**Consultation Response from: KC Environmental Health (Pollution & Noise Control)**

**2024/92701 South Pennine Boat Club, Wood Lane, Mirfield, WF14 0ED**

**Discharge of details reserved by condition 4 (Phase I Report) on previous permission 2024/90013 for erection of extension and alterations to enclose dry dock**

**Responding Date:**  
8<sup>th</sup> October 2024

Figure 7: Schematic of passive ventilation layer (NTS)

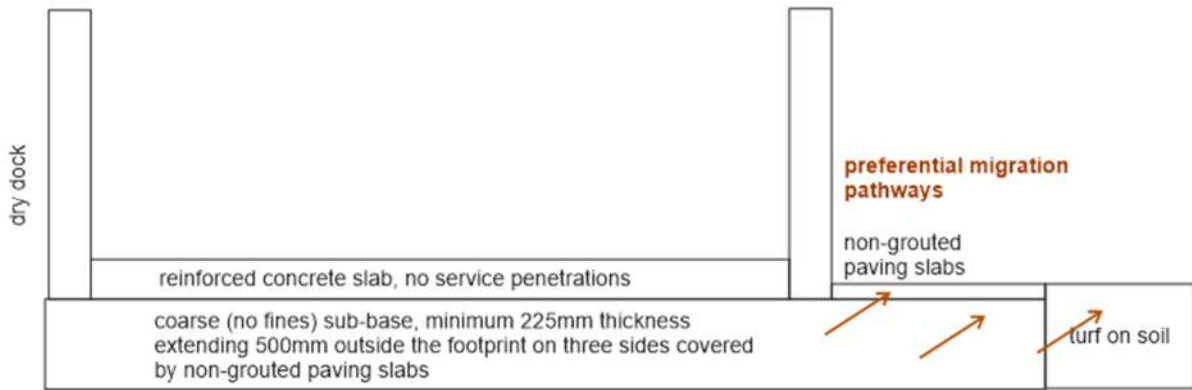
Despite the very low, low to negligible risk, the report goes on to suggest site remediation, including testing of soils and a vapour barrier in addition to a reinforced concrete slab. We would require clarification of this position with an application for the discharge of condition 5.
